20th January 2022

Application Nos.: 21/02337/DISC and 21/02339/REM

Proposal: Discharge of various conditions and reserved matters for first phase of 500 dwellings

Location: Proposed Himley Village North West Bicester
Middleton Stoney Road
Bicester
Oxfordshire

Illustrative elevation along a formal frontage | Not to scale

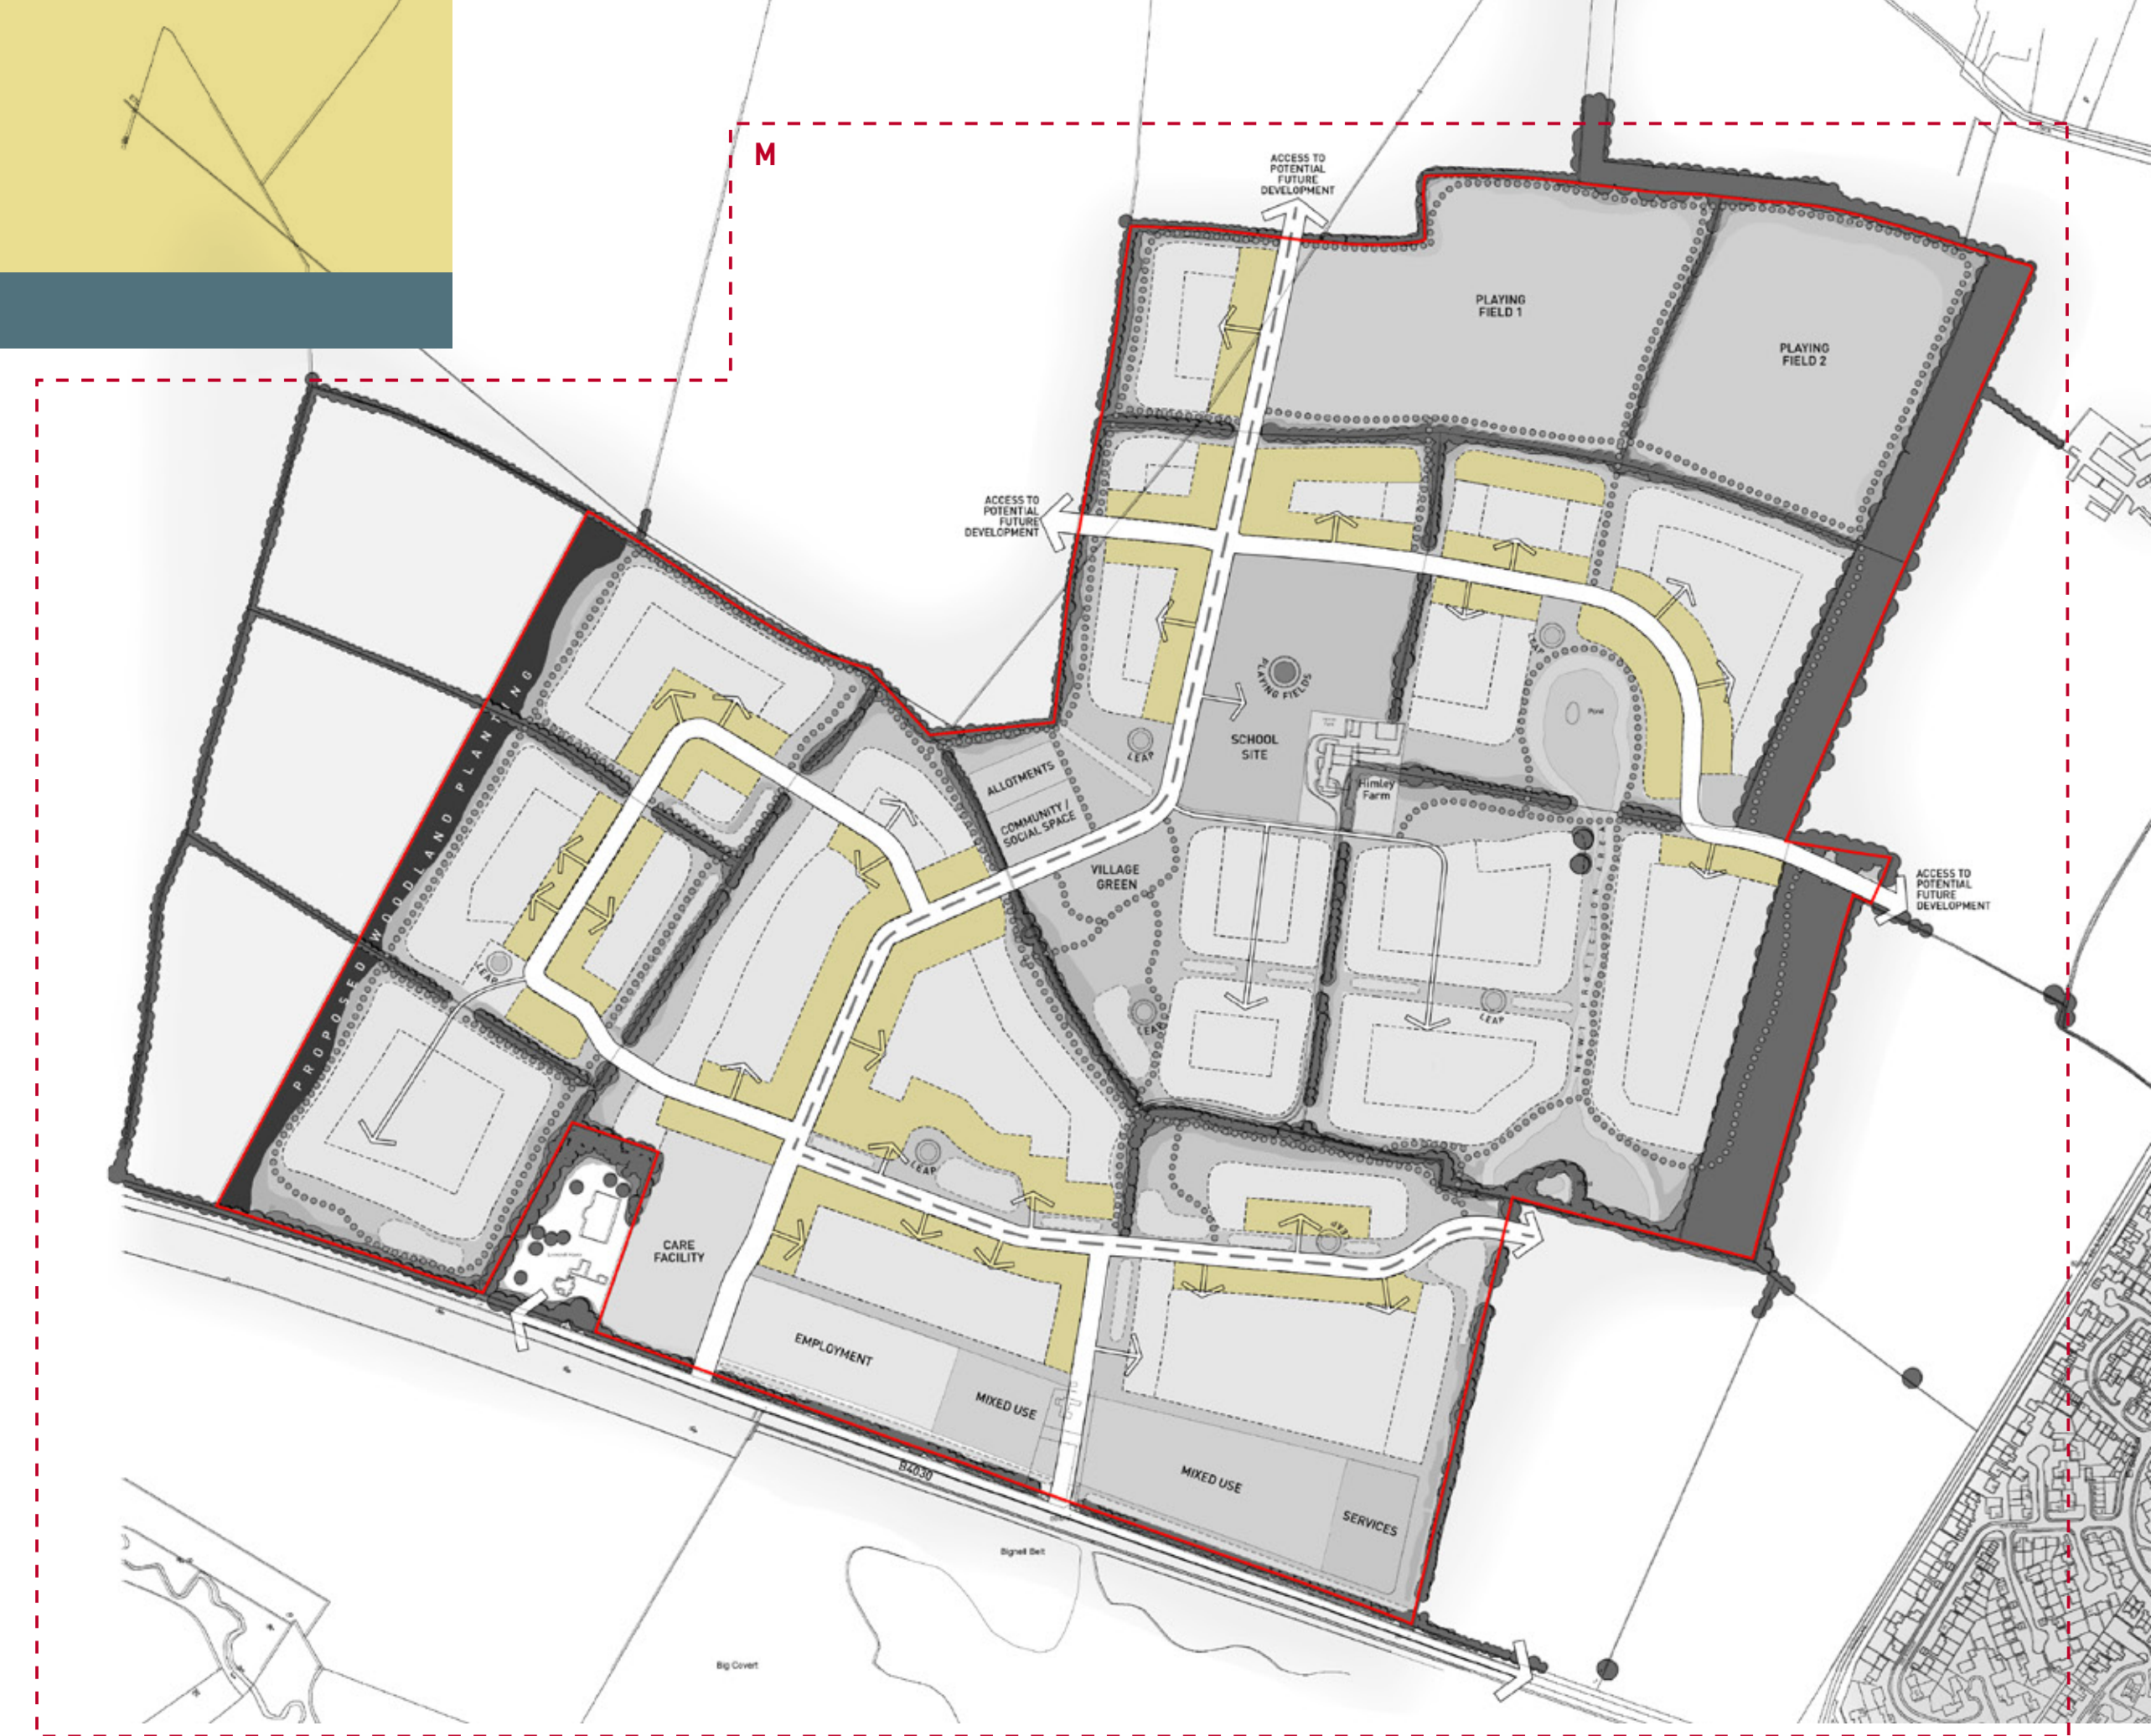
- Please confirm where the illustrative elevation along a formal frontage shown on page 52 is taken from. In comparison to this, whilst a key characteristic of the Georgian character area is a 'strong, continuous frontage to ... create a sense of enclosure and define the street scene', the reserved matters submission instead indicates a gappy street scene in such a character area made up of

semidetached units with garaging in between which backs onto the primary street. This proposal is not in compliance with the Design Code (street scene AA provided again):

Illustrative elevation along a formal frontage | Not to scale

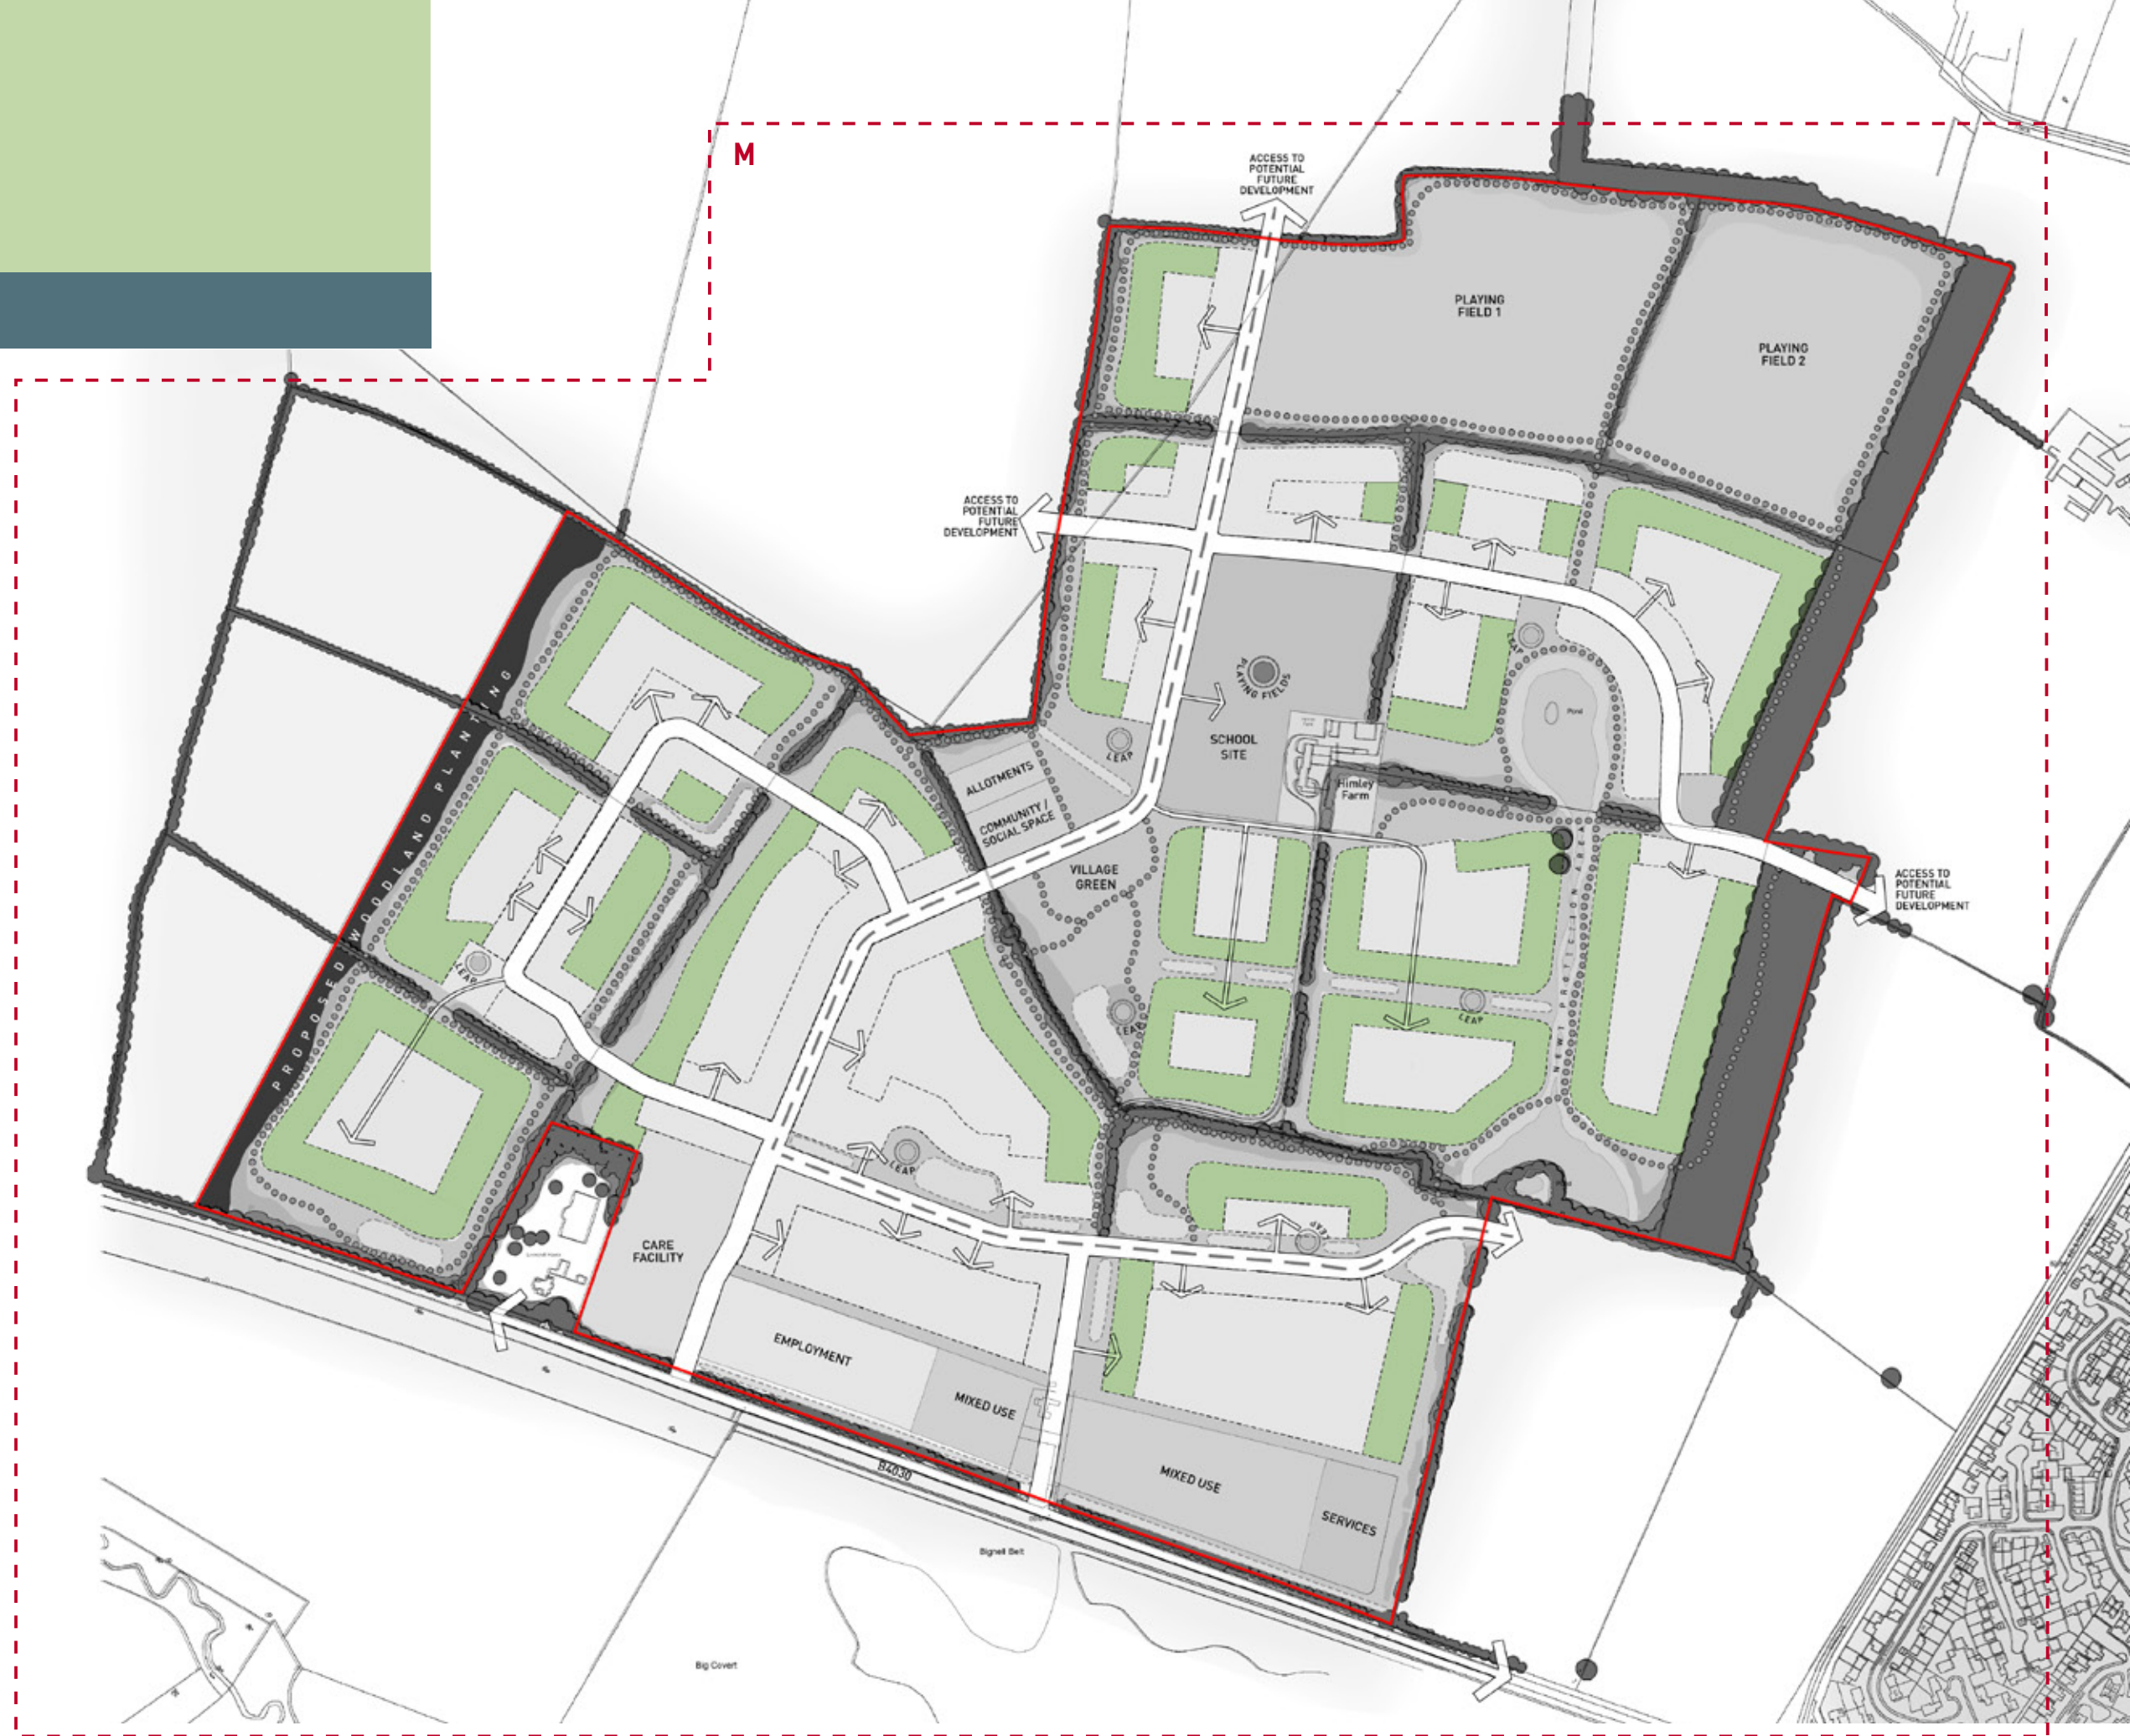
- Within the Contemporary Character Area, it is stated that there is the ‘opportunity for contemporary architecture’ – This lacks clarity and I’m not convinced this could be considered a ‘mandatory’ requirement given it is only stated to be an ‘opportunity’.

- It is stated that the roofscape would be punctuated by chimneys – is this suitable on a contemporary building type? It could be that roof features are proposed if passive ventilation is proposed – is this what is meant rather than a traditional ‘chimney’?

- What is meant by ‘contemporary architecture’? What is the character and what defines this for this particular site?
- The imagery shown for the contemporary type is almost completely taken from Elmsbrook – including the description of ‘contemporary windows’. Earlier, references are to ‘Georgian influences’ on these windows – this indicates some confusion. The door styles suggested for the ‘Contemporary’ character area is worded exactly the same as the door styles for the ‘Georgian’ character area (with those words changed to suit the area). This is clearly inappropriate for such differing character areas.

Illustrative section along employment and residential boundary | Not to scale

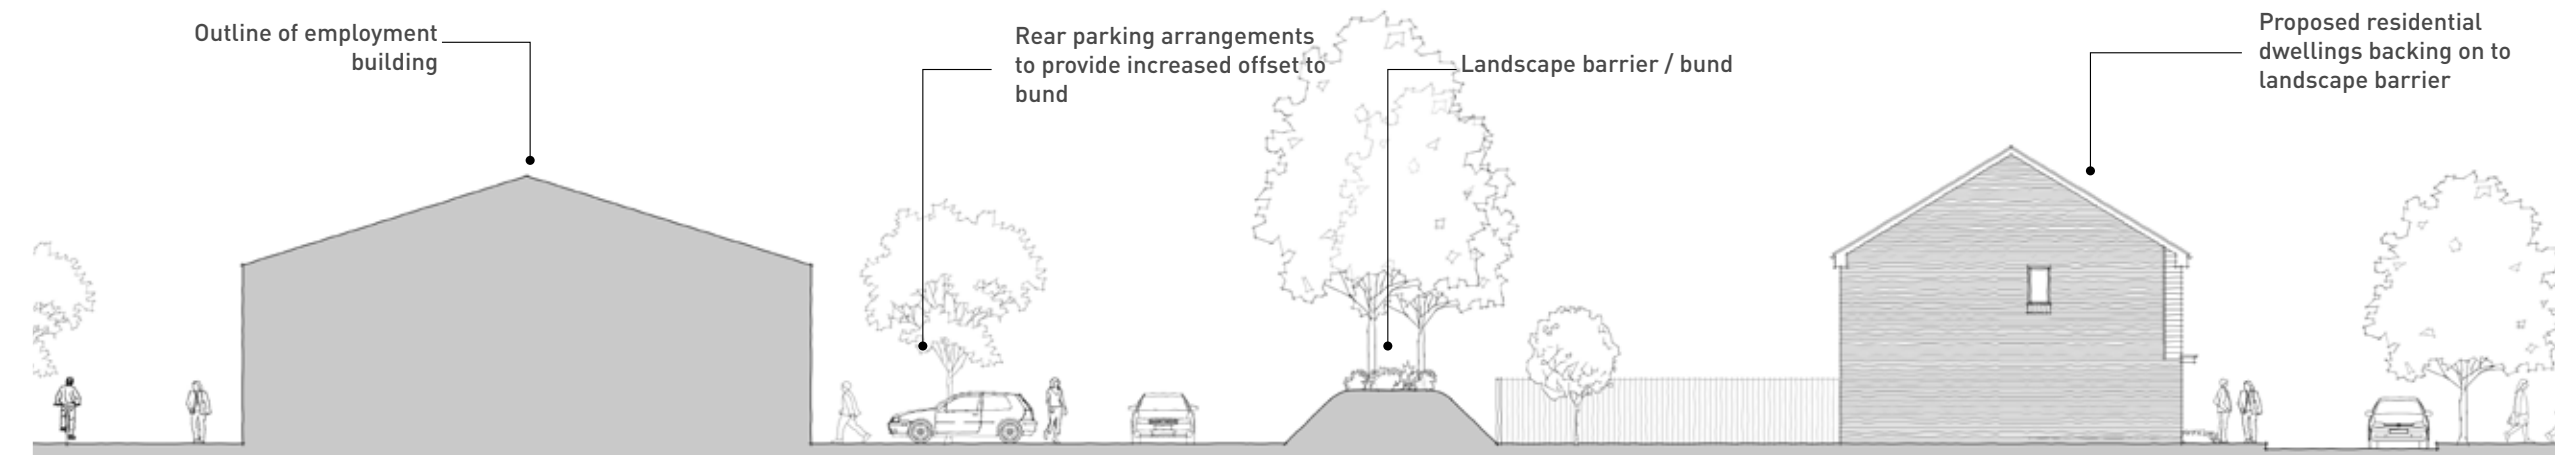
- The illustrative section is inconsistent with the key characteristics listed – such as ‘feature swales and landscape buffers are provided along the northern and southern boundaries...’. No such features are visible on the section drawings. I would suggest that this introduces uncertainty for the interpretation of the Code.
